**Jeanie Bourke - Re: 129 Spring St., BP#2014-02913 plan review comments**

**From:** Jeanie Bourke  
**To:** HOME Catering Co.  
**Date:** 2/12/2015 1:50 PM  
**Subject:** Re: 129 Spring St., BP#2014-02913 plan review comments

129 Spring St. Proposed Floor Plan

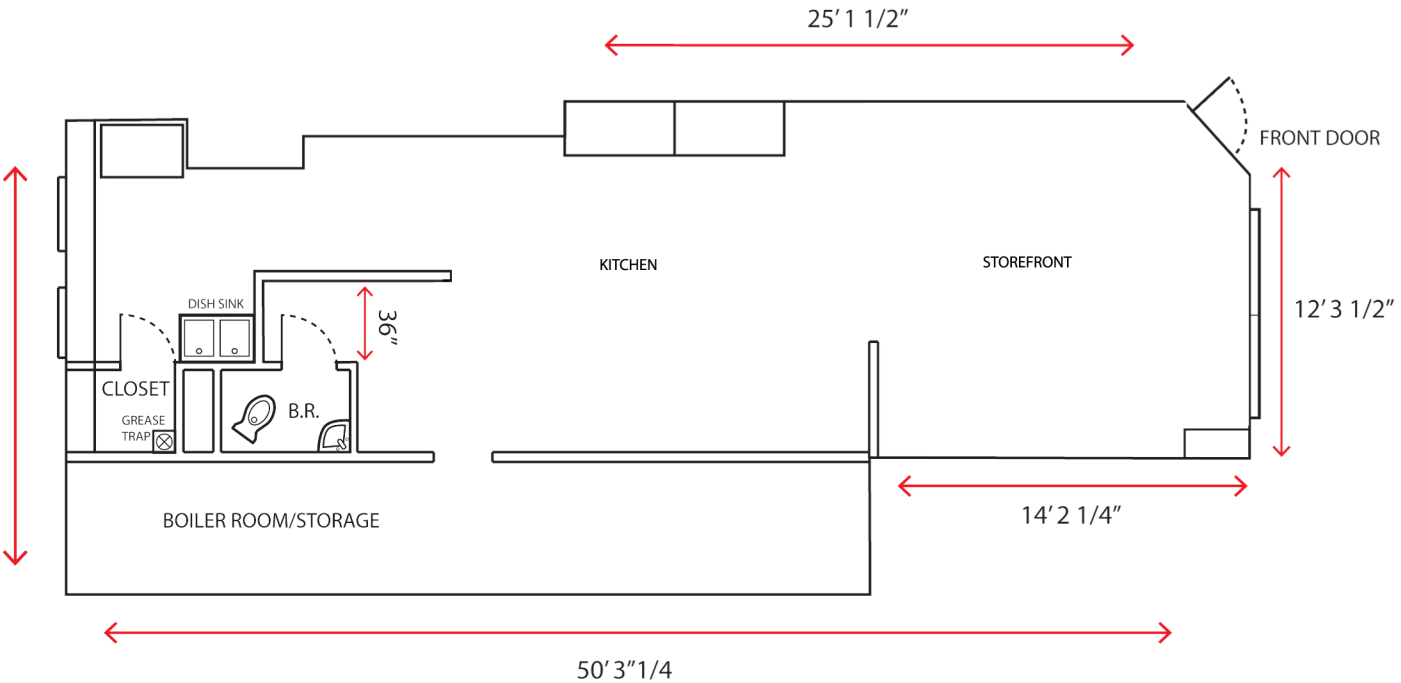
1. Is there a currently a suppression hood? If not, this is required for grease vapors and even though a separate permit is required, this will also need to be included for this permit for the exhaust location and for historic review.

2. Have you consulted with the Public Health inspectors for fixture requirements, specifically the 2-bay sink?

1. There is not currently a fire suppression hood as all equipment is electric and will be used for general heating of soups, bread, etc. A proposed menu was submitted to Health and Public Services on December 16th. All kitchen equipment and systems are the same as were in use at Miyake Diner and Food Factory Miyake.
2. I apologize for the sketch. I did my best to label the sink as a three bay, but I was unable to find the appropriate graphic to represent it as such on the plan. The sink is, in fact, a three bay sink and I have spoken with Frank Brancely at Public Services about it and the newly required grease trap which is on order.

129 Spring St. Proposed Floor Plan

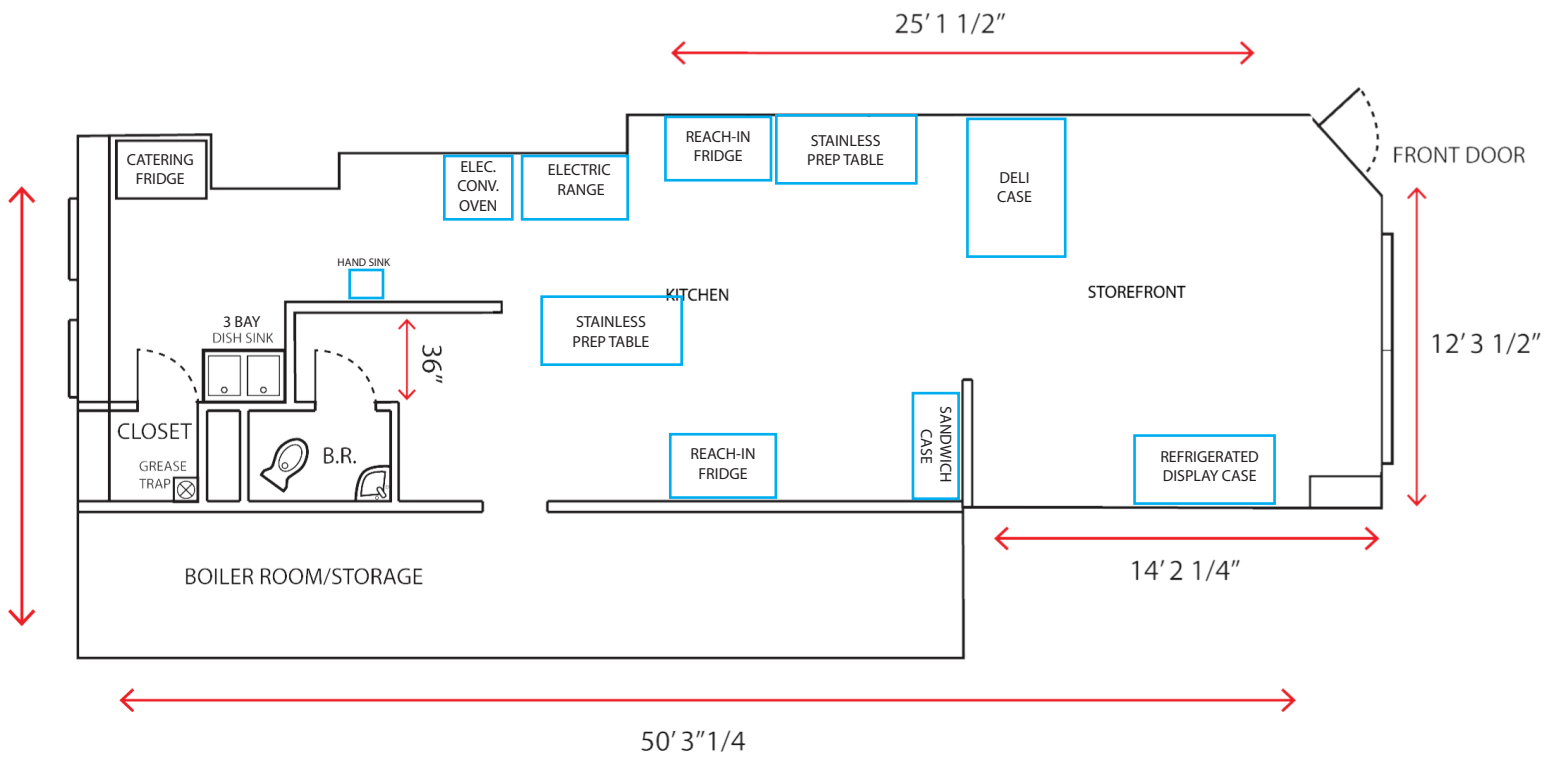
Thank you so much for your help. Attached is the revised floor plan you requested with kitchen plumbing and proposed equipment labelled in blue. Please let me know if you need any further info.

Thanks for the clarification. The hood requirement is based on products cooked and if grease vapors are created, not if the equipment is electric or gas. There certainly are gas venting/exhausting requirements as well.

I will approve the permit based on the information you have provided. The permit appears to remain in review for historic preservation.
